From: Paul Cann
Sent: 01 December 2017 14:11
To: Ross Leal
Subject: RE: WA/75/17/PL - Land adjacent to Sunny Corner, Copse Lane, Walberton

From: Mark Akmenkalns [REDACTED]
Sent: Monday, November 6, 2017 10:38 AM
To: Paul Cann <Paul.Cann@arun.gov.uk>
Cc: Chris Purdy (MHA) [REDACTED] Susan Leeson [REDACTED] Julia Holden [REDACTED]
Subject: D1271: 17025 Sunny Corner - LPA Drainage Review/Response 17-11-06

Drawing title								
Proposed Site Excerpt								
Drawn	Date	Checked	Date	Scale at A3				
CJP	Nov 17			1:200				
Job No.	Pro.	Org.	Zone	Level	Type	Role	No.	Rev.
17-025	SCR	MHA	00	XX	DR	A	SK03	P01
Purpose of Issue								
SKETCH FOR DISCUSSION

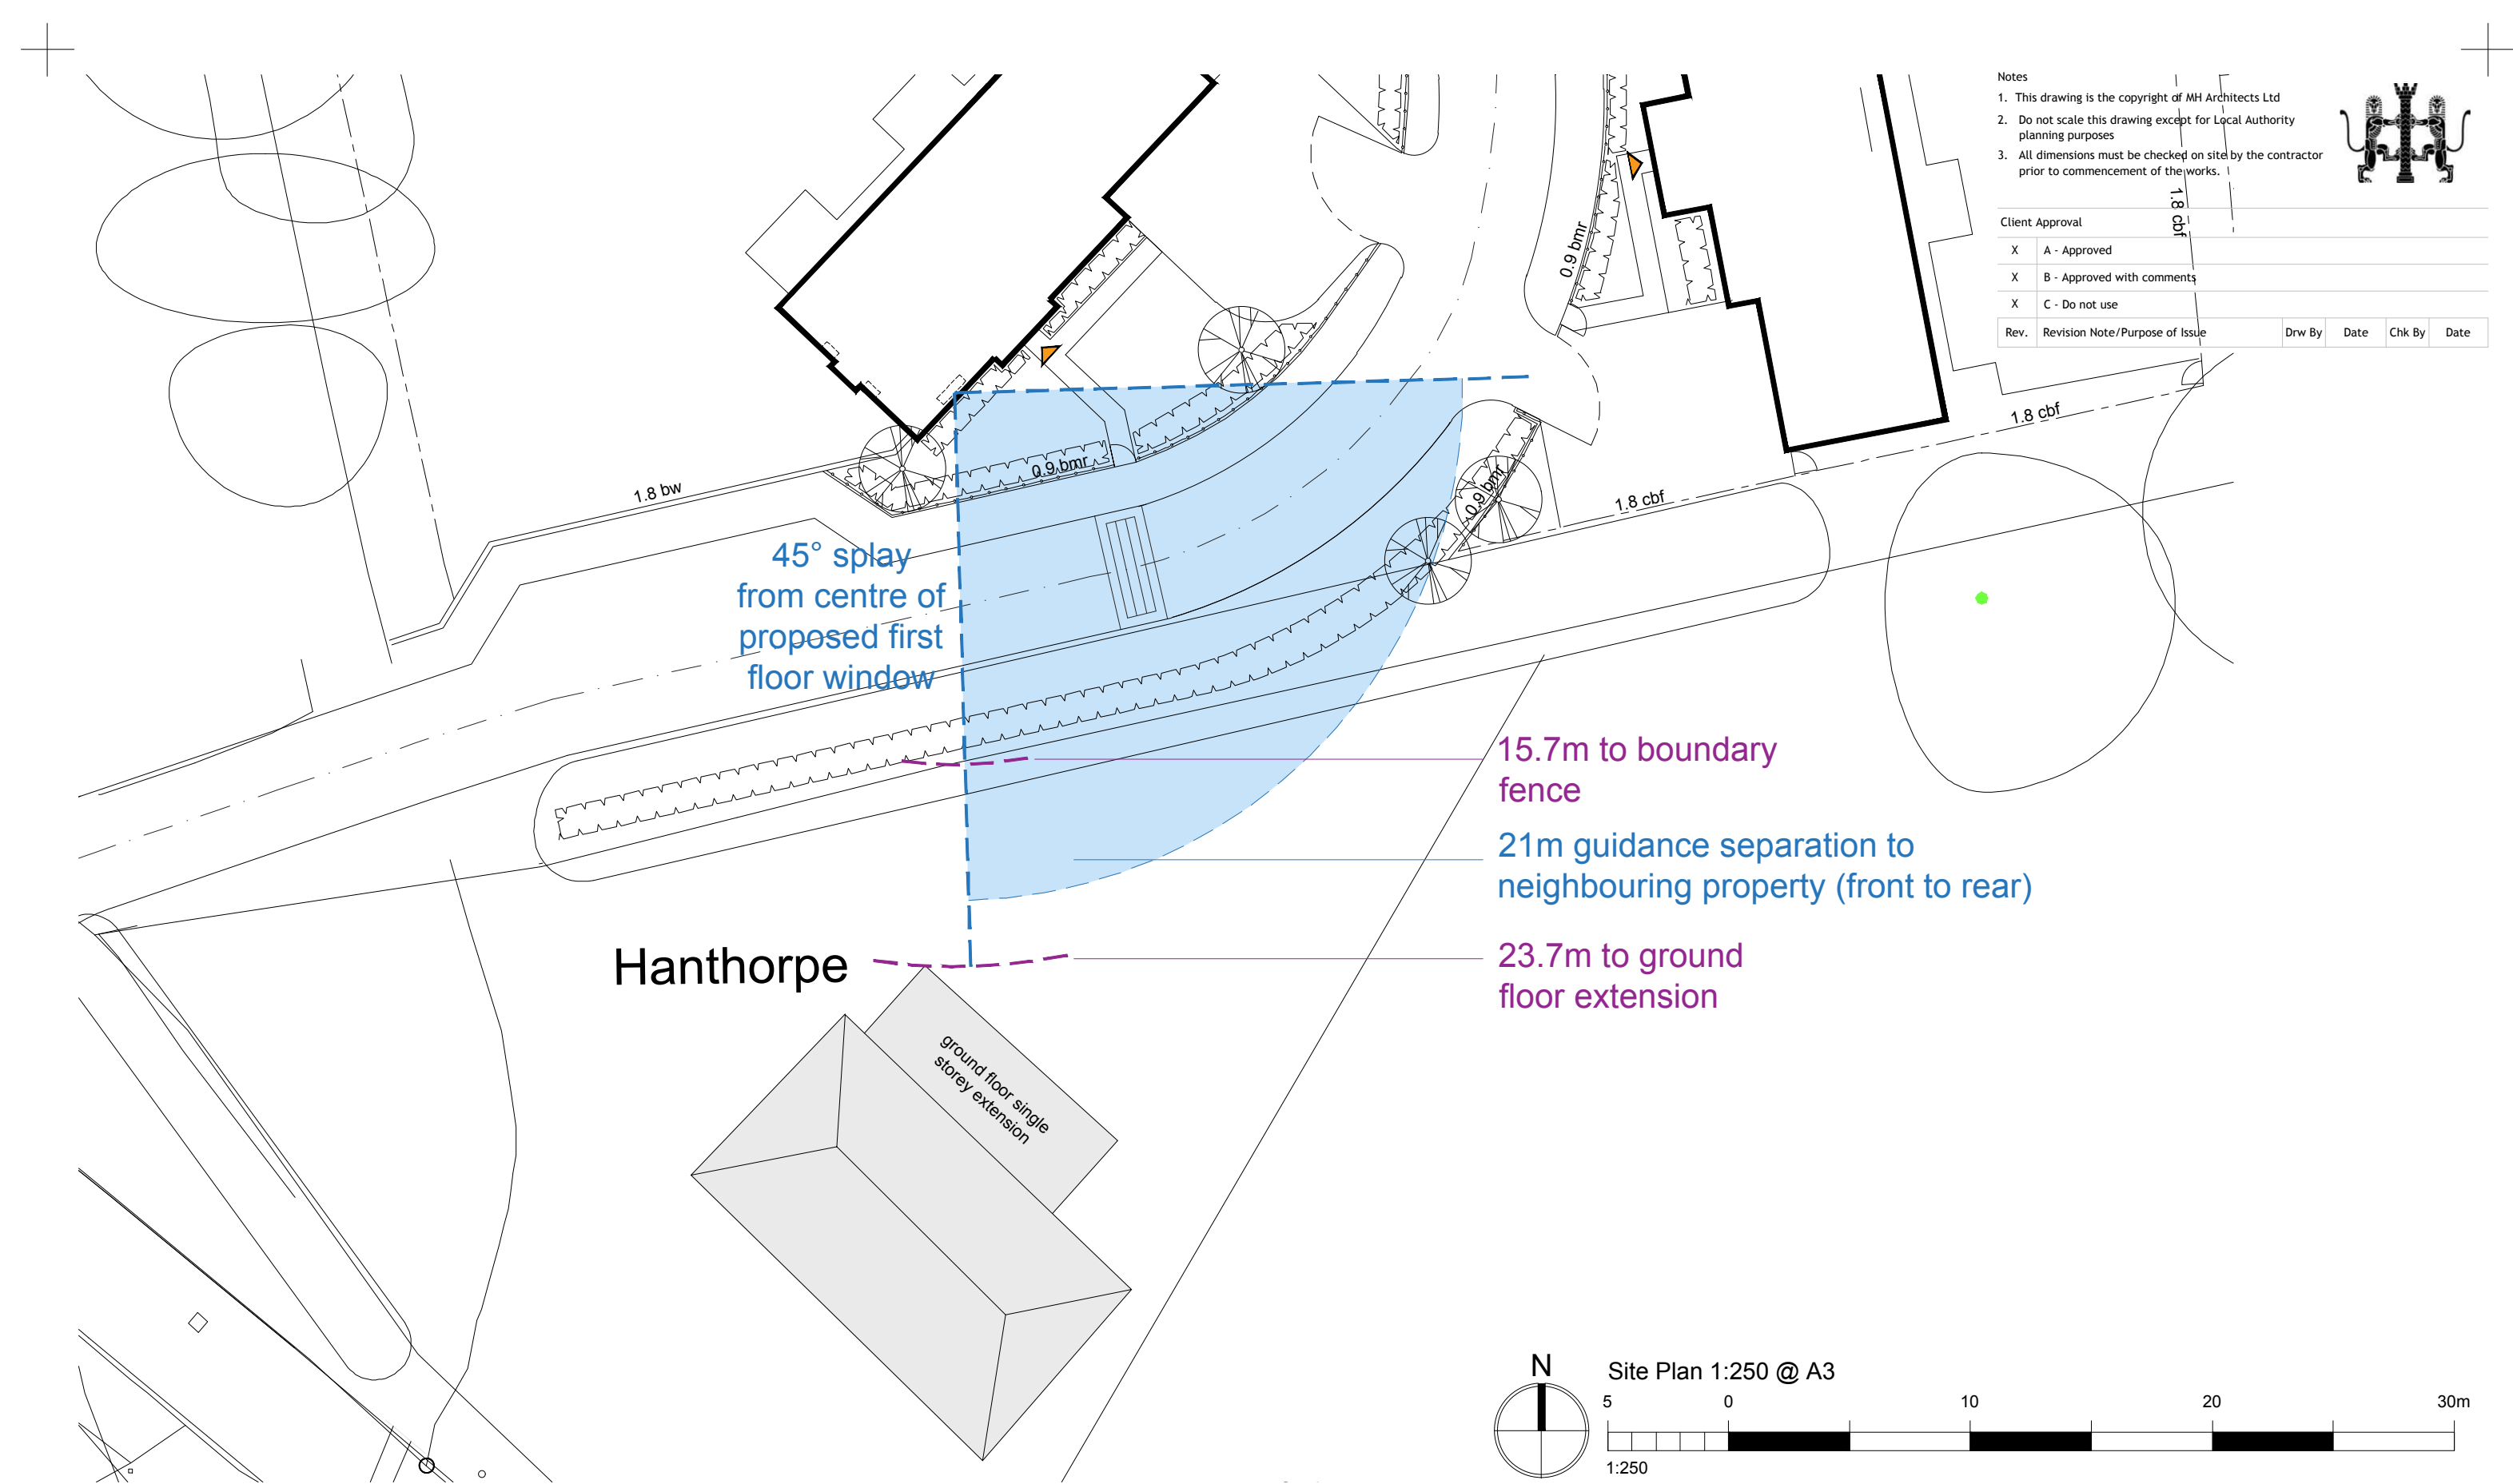
For clarification I attach an extract for the fence proposals in vicinity of plots 1 & 2 on the western boundary. A 3m maintenance strip will be provided from 'top of bank' and demarcated by way of a nominal 1.2m ht post and rail fence. The Plot 1-2 dividing fence will be cut back accordingly.
